State of Washington
DEPARTMENT OF FISH AND WILDLIFE

April 30, 2026

SUBJECT: WDFW COMMENTS ON SE-26-00001 Easton Travel Center

SCALE GRAPHIC	EASTON TRAVEL CENTER	SHEET
DRAWN BY: LVE	PARCEL SITE PLAN	1
CHECKED BY: LVE	EASTON, WA	
SURVEYED BY:	DATE: FEBRUARY 13, 2024

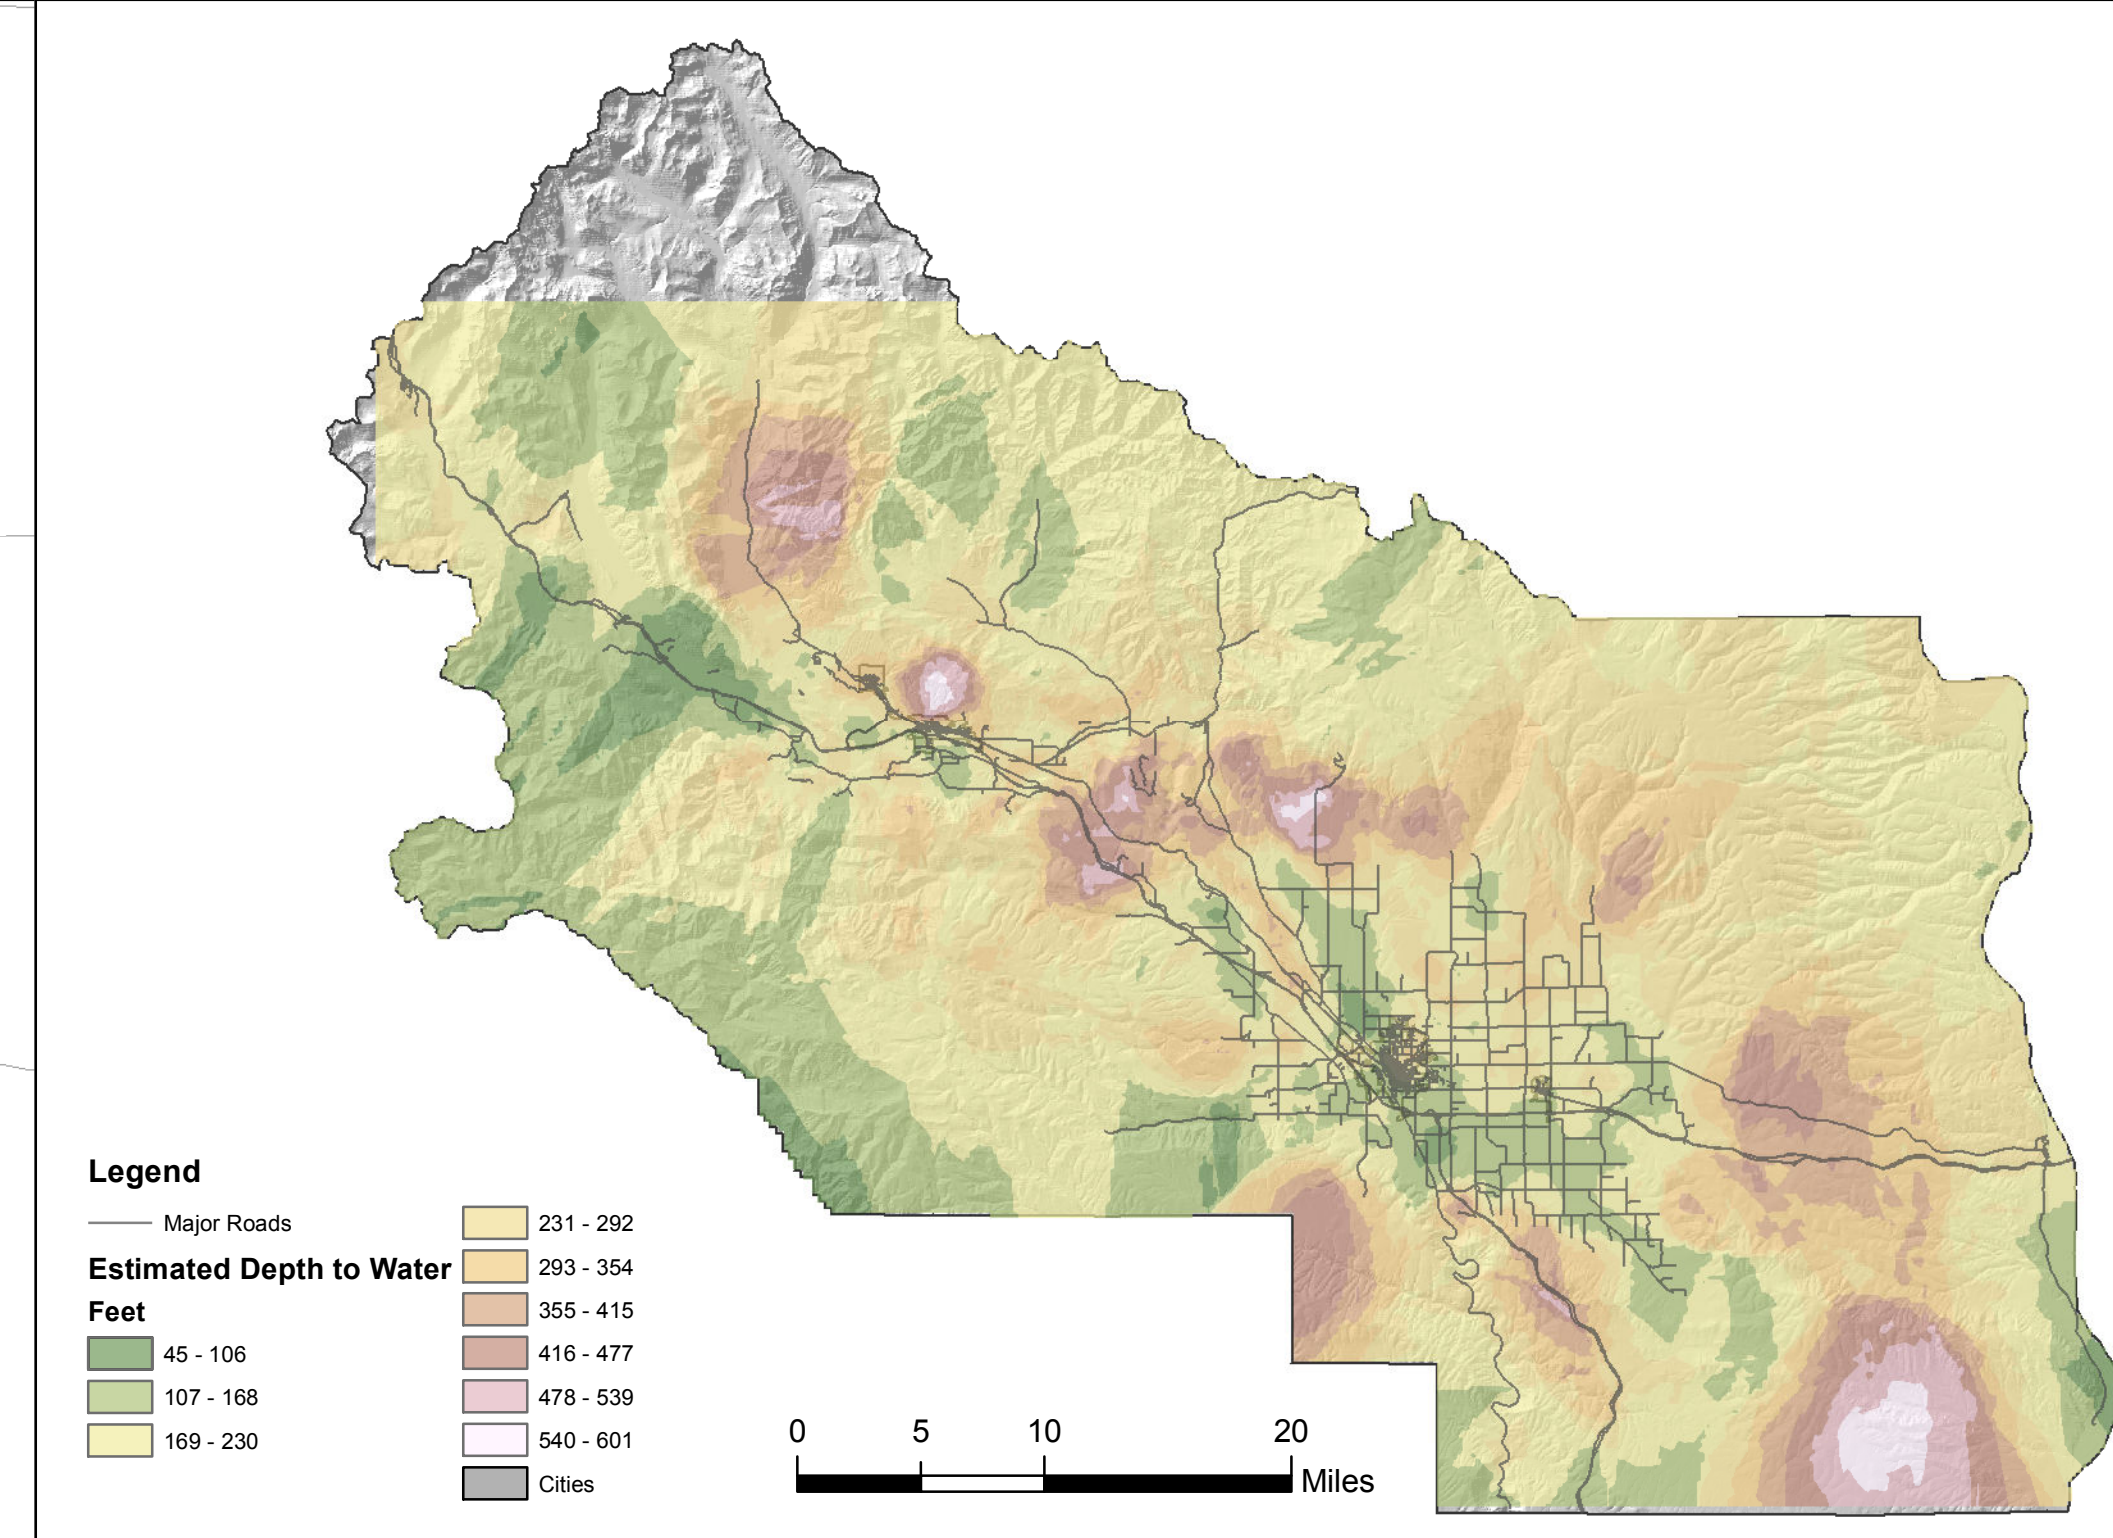
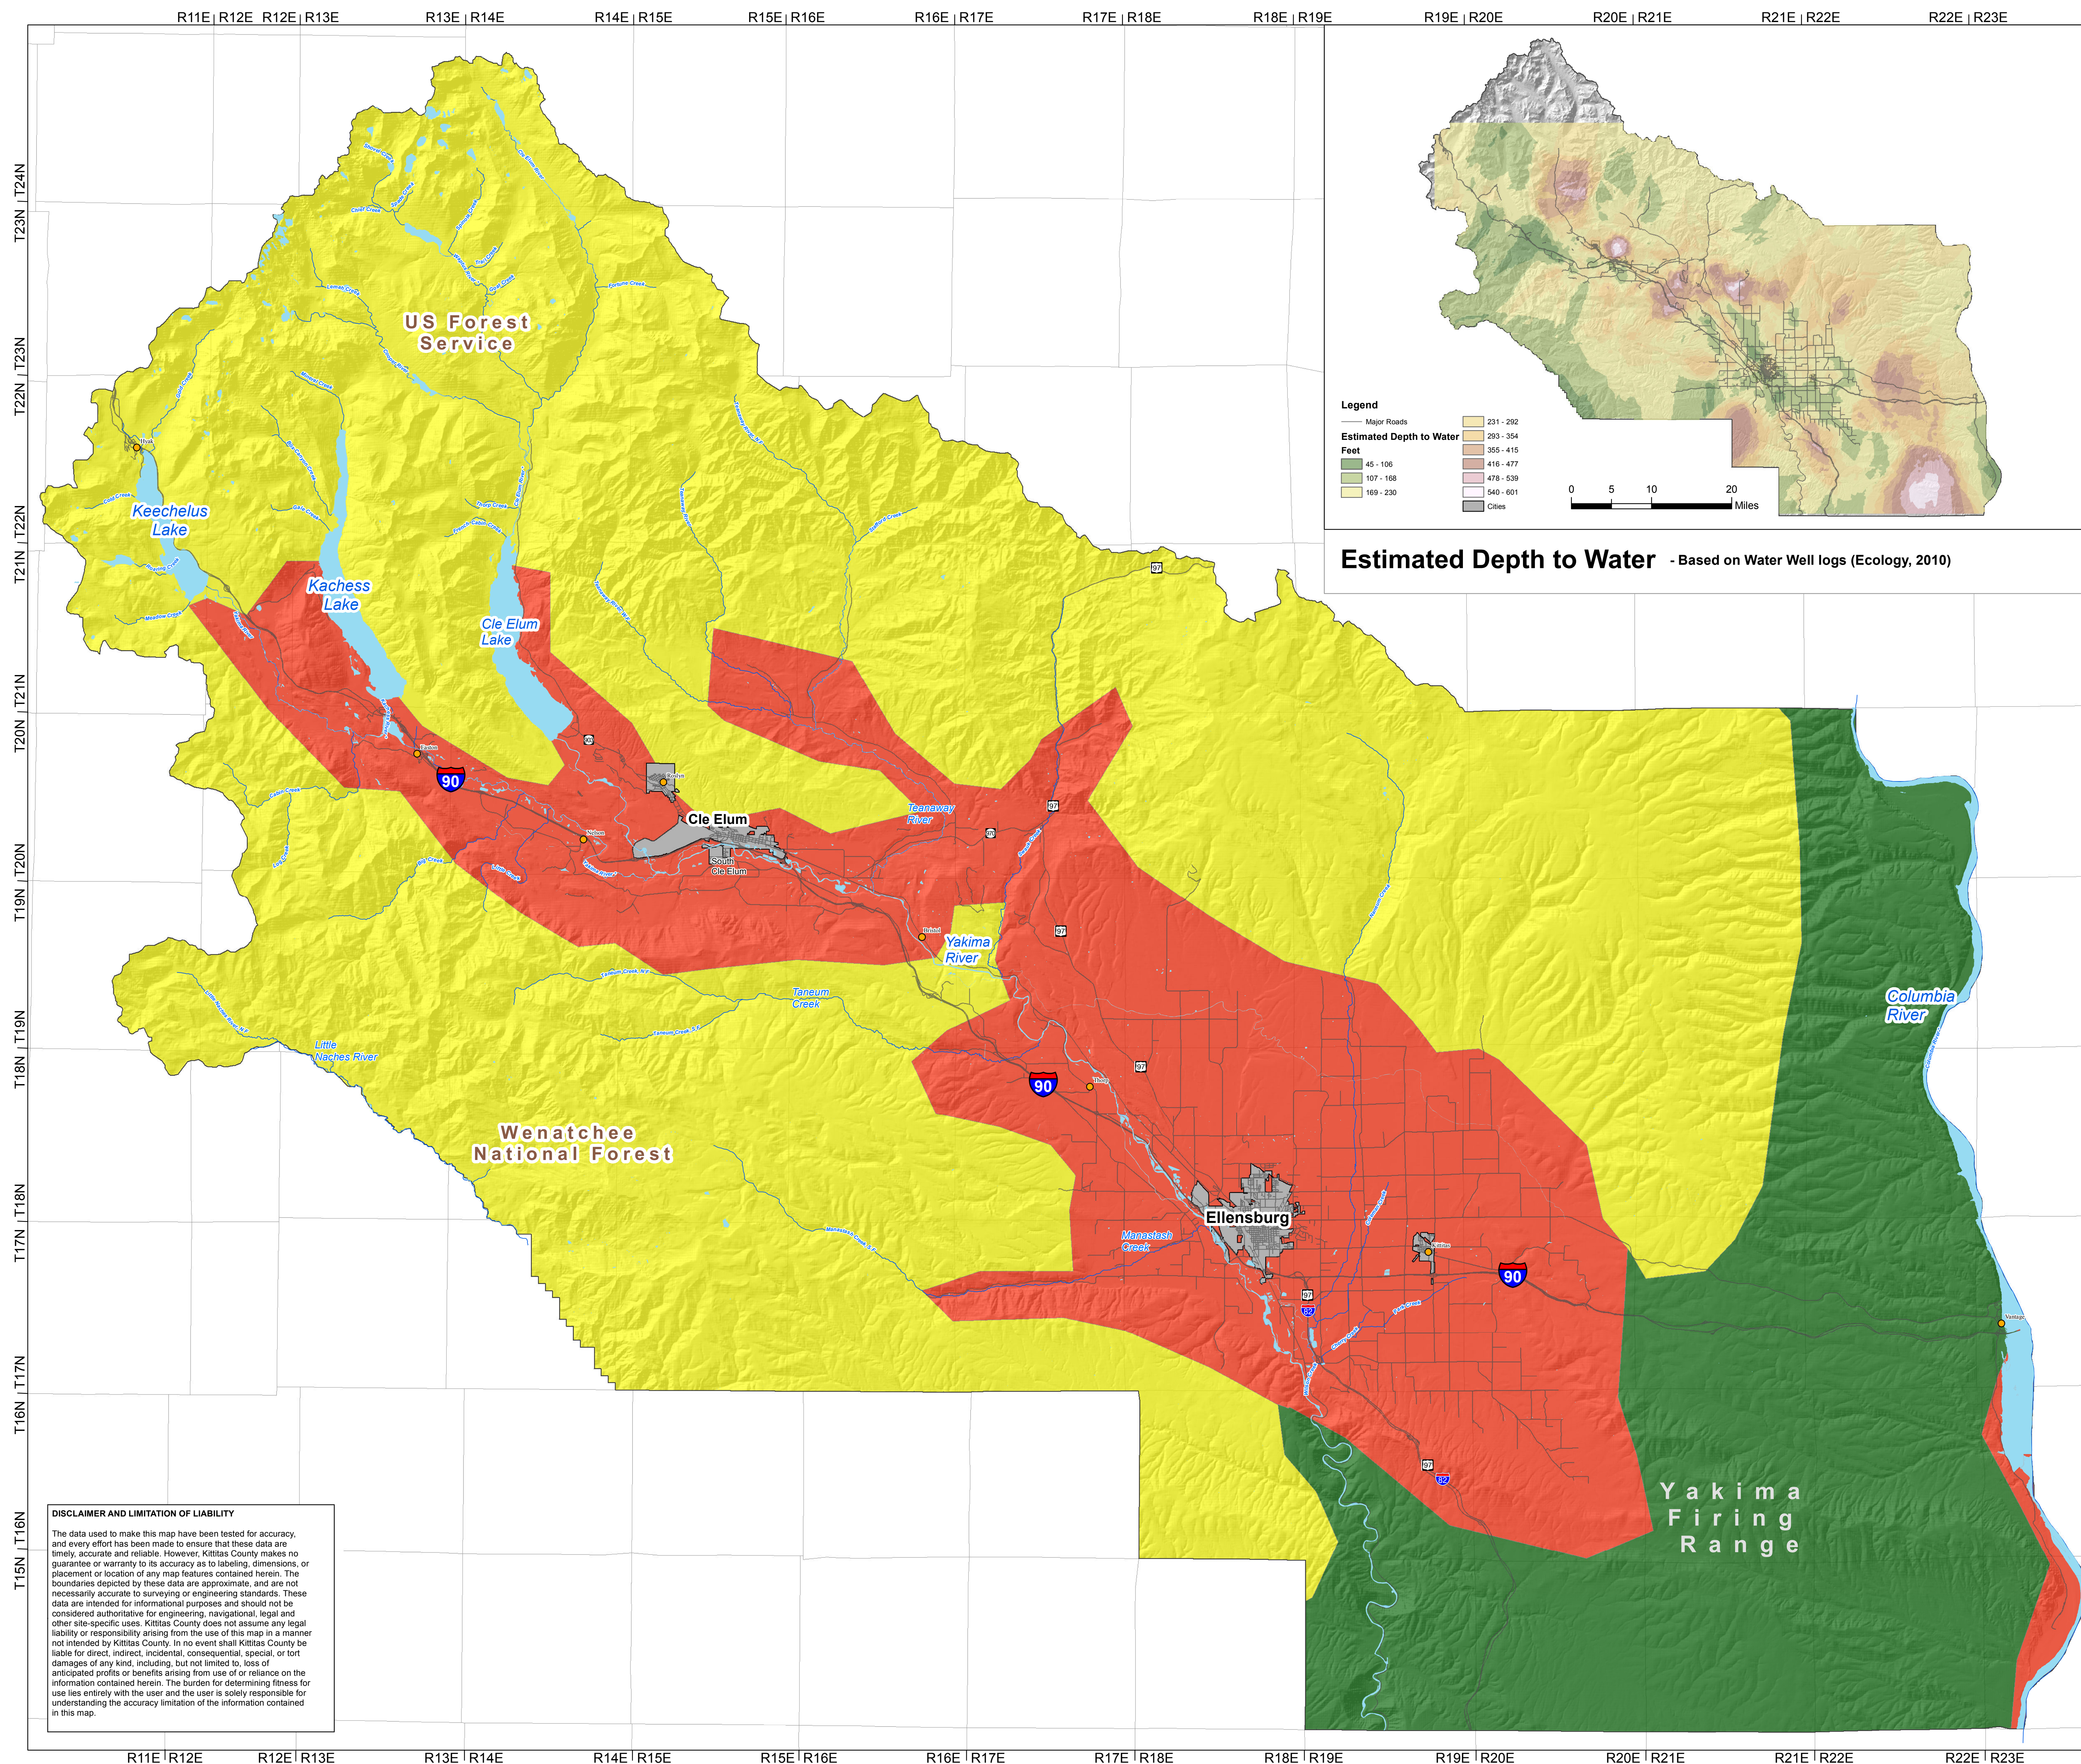
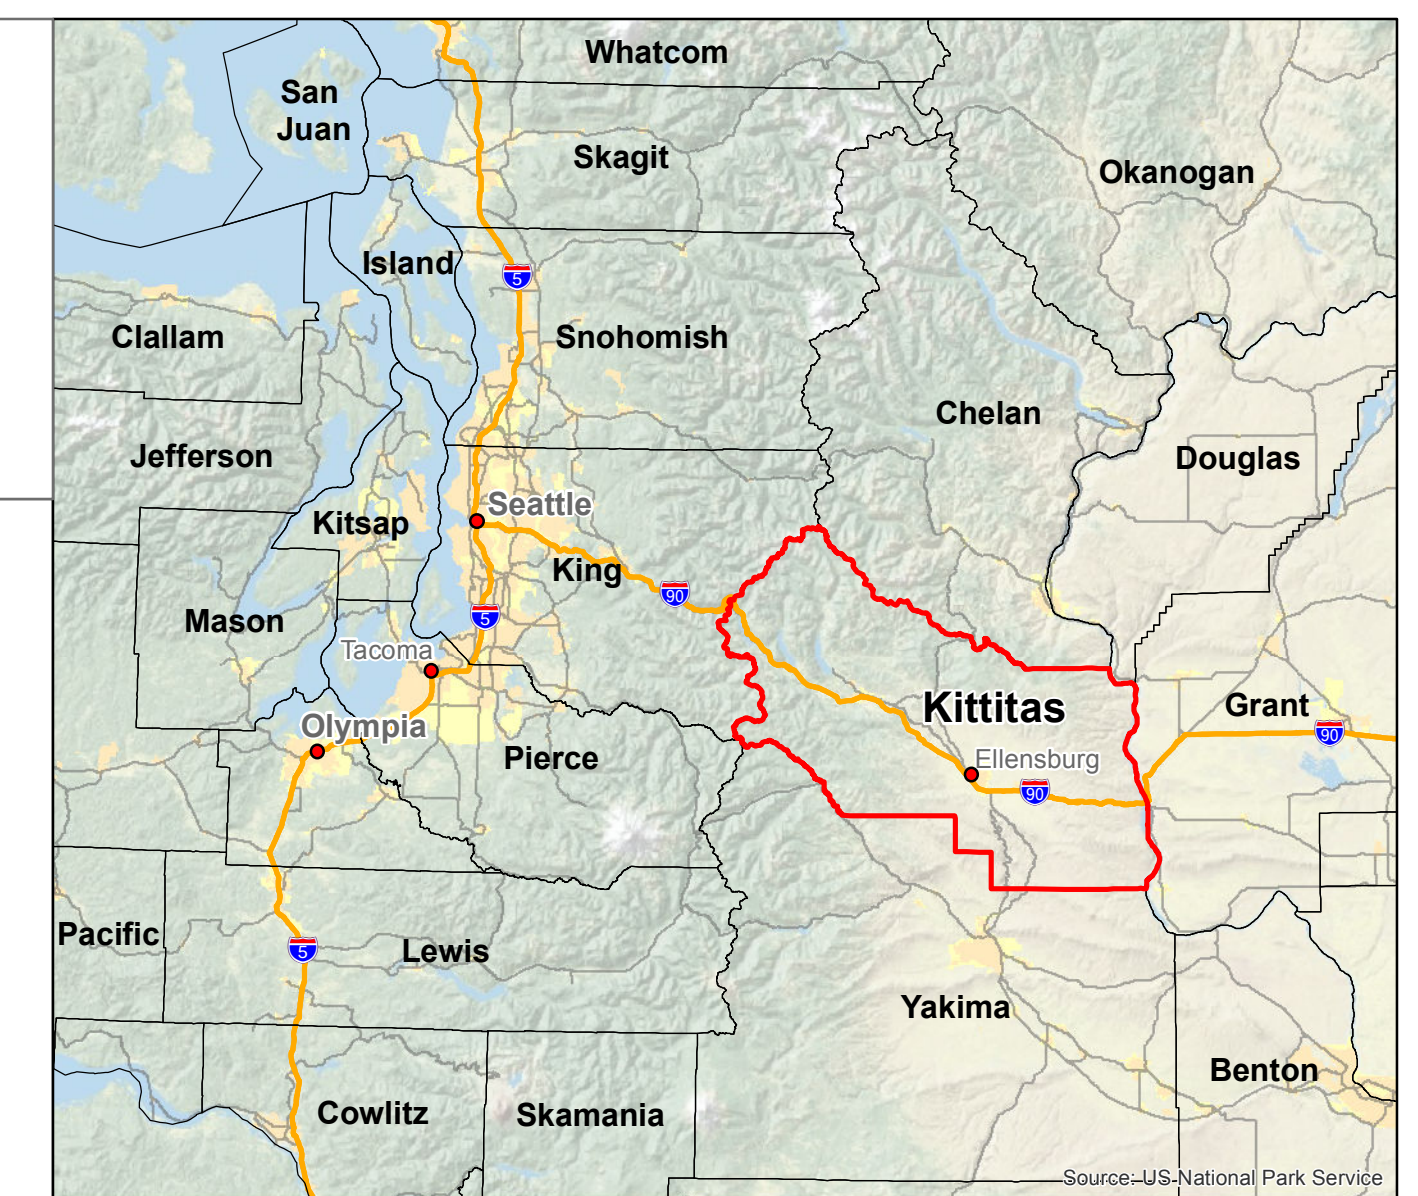
- a. WDFW requests that the clearing limits be restricted to only the absolute minimum needed to build the proposed Travel Center.
- b. Revegetation of temporary impacted areas; revegetated with native vegetation from the area to help offset the losses of forested habitat. If the applicant has questions or needs assistance in how to replant with native vegetation and/or avoid some of the forested area, WDFW would be willing to assist from a habitat perspective.
- c. To offset habitat impacts, WDFW would like the applicant to consider donating some of the cleared trees to nearby habitat projects. WDFW can assist in coordinating those discussions.

To lessen the Travel Center's impact on nocturnal wildlife movement, we request that all outdoor lighting be facing the ground. Lighting geared towards the sky can have attractancy issues for nocturnal flying wildlife, including birds. [WDFW's Priority Habitats and Species Map](#)

includes occurrence of Little Brown Bat and Yuma myotis bat in the project vicinity and the project area may provide roosting bat habitat. WDFW recommends preserving as much of the forest as feasible and placing bat boxes on the forested portion of the property to help offset the impact. WDFW can provide technical assistance, as needed.

Lastly, the SEPA mentions stormwater will be maintained on site in accordance with the EWSWM and flow into engineered swales. With the amount of vegetation removal and increased impervious surface in a high snowfall area, a detailed drainage plan should be completed. The plan should demonstrate that drainage from the site can be properly managed and will not contribute to the degradation of nearby fish-bearing waters such as Lake Easton and Silver Creek.
